**RE: Proposed Dwelling Chestnut Tree Farm Hoxne Eye Suffolk**

Further to the grant of revised Planning Approval under reference 4370/15 and which has been crystallised on site by way of a verified material start, please find attached our S96 Application.

JOB : 2508/S96 DRAWING : 01/01 DATE : January 2024 TITLE : Elevations - existing : proposed SCALE : 1:100

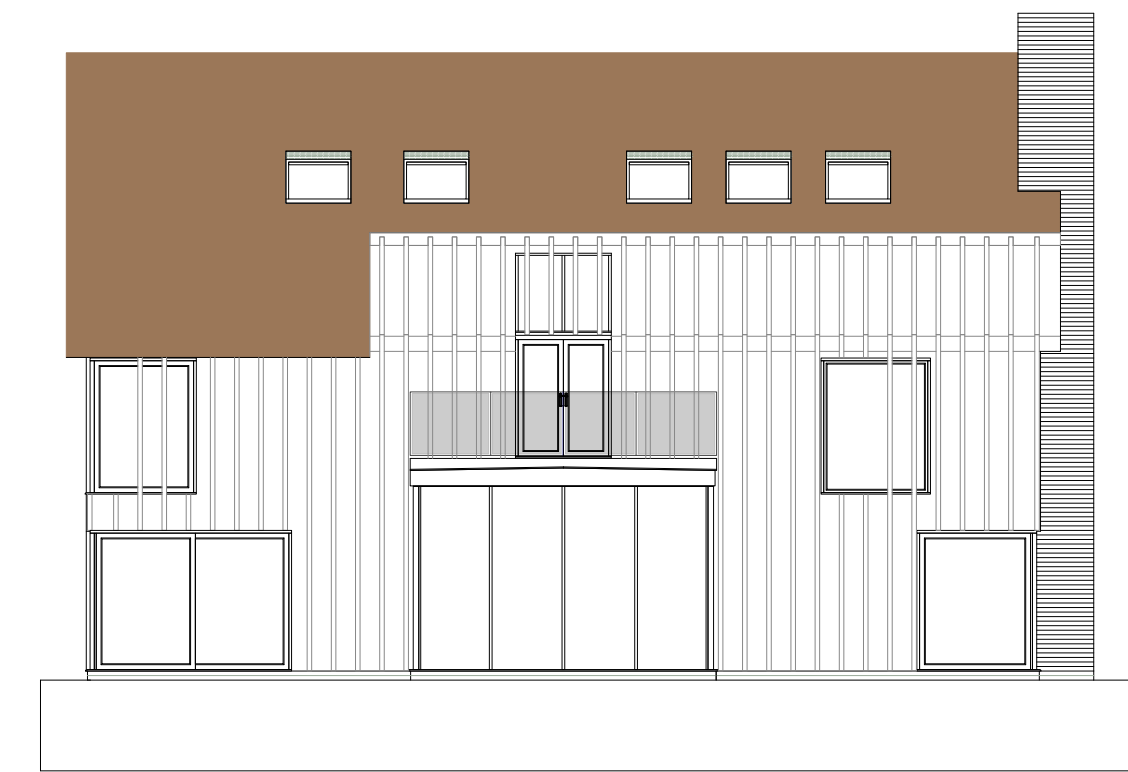
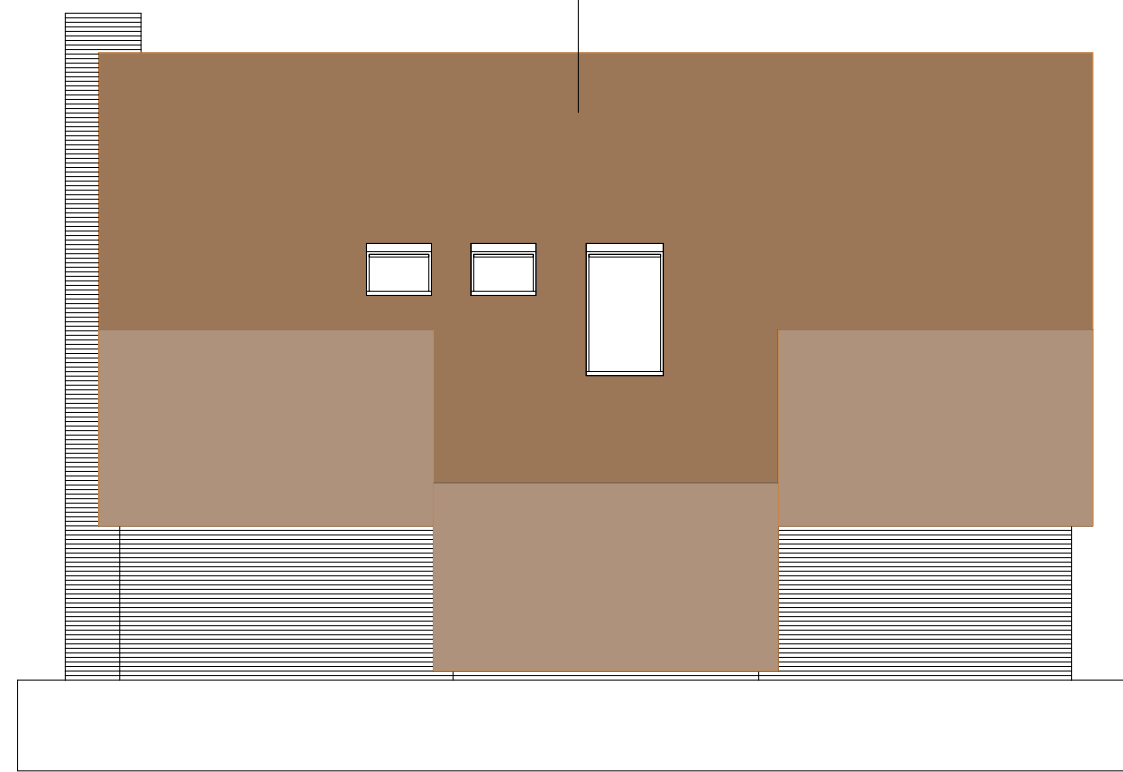
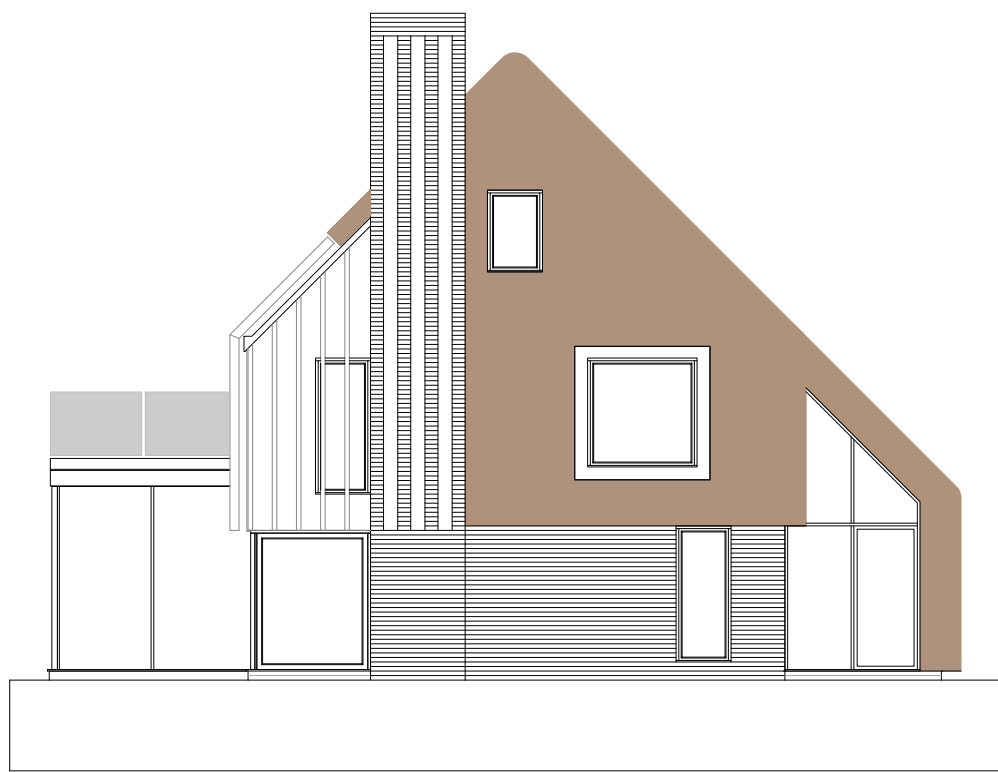
As approved, the dwelling is shown to have thatch (reeds) as a roof covering and continuously, in certain locations, also as a wall covering. The applicant has been, for many months, seeking to engage a thatcher would install the vertical thatch and give any form of assurance of its on-going integrity. Following recent discussions a solution has now been found which will allow the thatch as Consented to be fixed. It is proposed to add a secret gutter to the roofs at the point which the pitched face transitions to the vertical. This will gather rainwater from the roof and help avoid it adding un-necessary weight to the vertical thatch. In addition, a small barge board will be added to the gables; this will cloak the exposed ends of the thatch.
